1 August 2014

Re: Little Stars, Ascot Way, Rustington - R/129/14/PL

I now have further information from my client concerning the matters raised by Environmental Health. This letter has two pages.

PROPOSED GROUND FLOOR PLAN

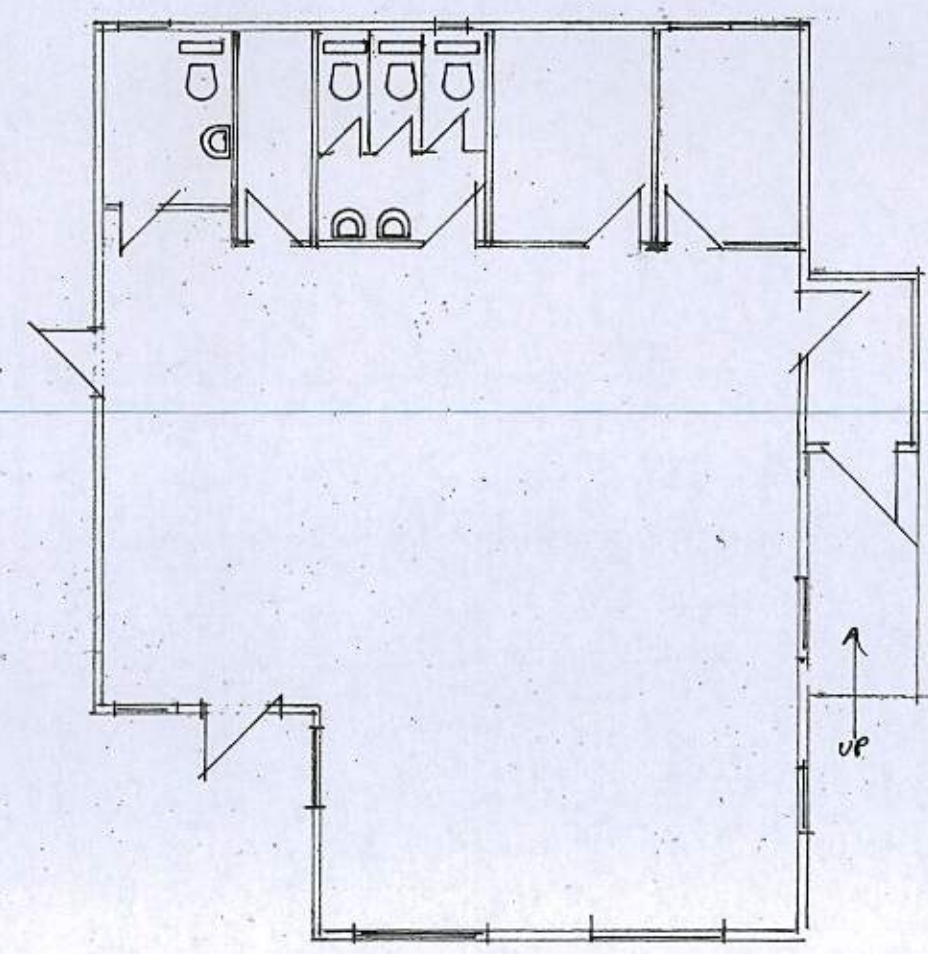
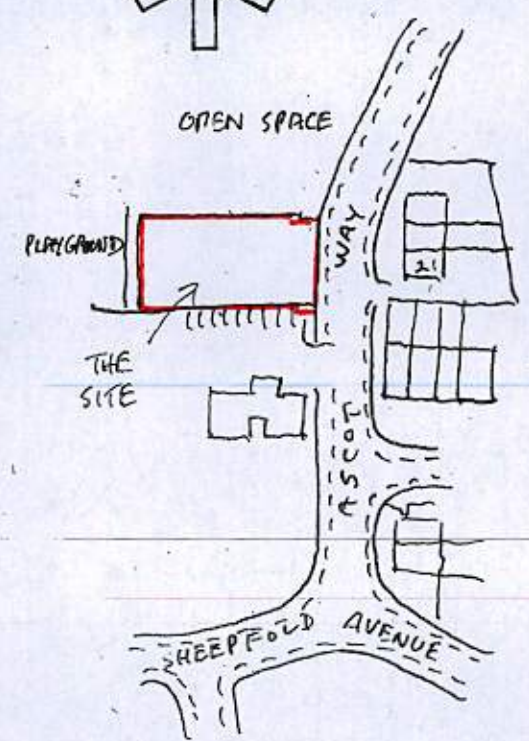
With regard to point 1 enclosed is a drawing dated to-day and numbered 6 showing the position of the kitchen in the proposed extension which will replace the existing smaller one. The exact layout within the kitchen has not been decided and a plan is awaited from the suppliers of the building. If the information in this letter is insufficient then I would ask that the matter is dealt with through a condition.

In respect of point 2 on the enclosed plan I have shown edged red the outside play area and this totals about 191 square metres. I have been told by my client as follows:
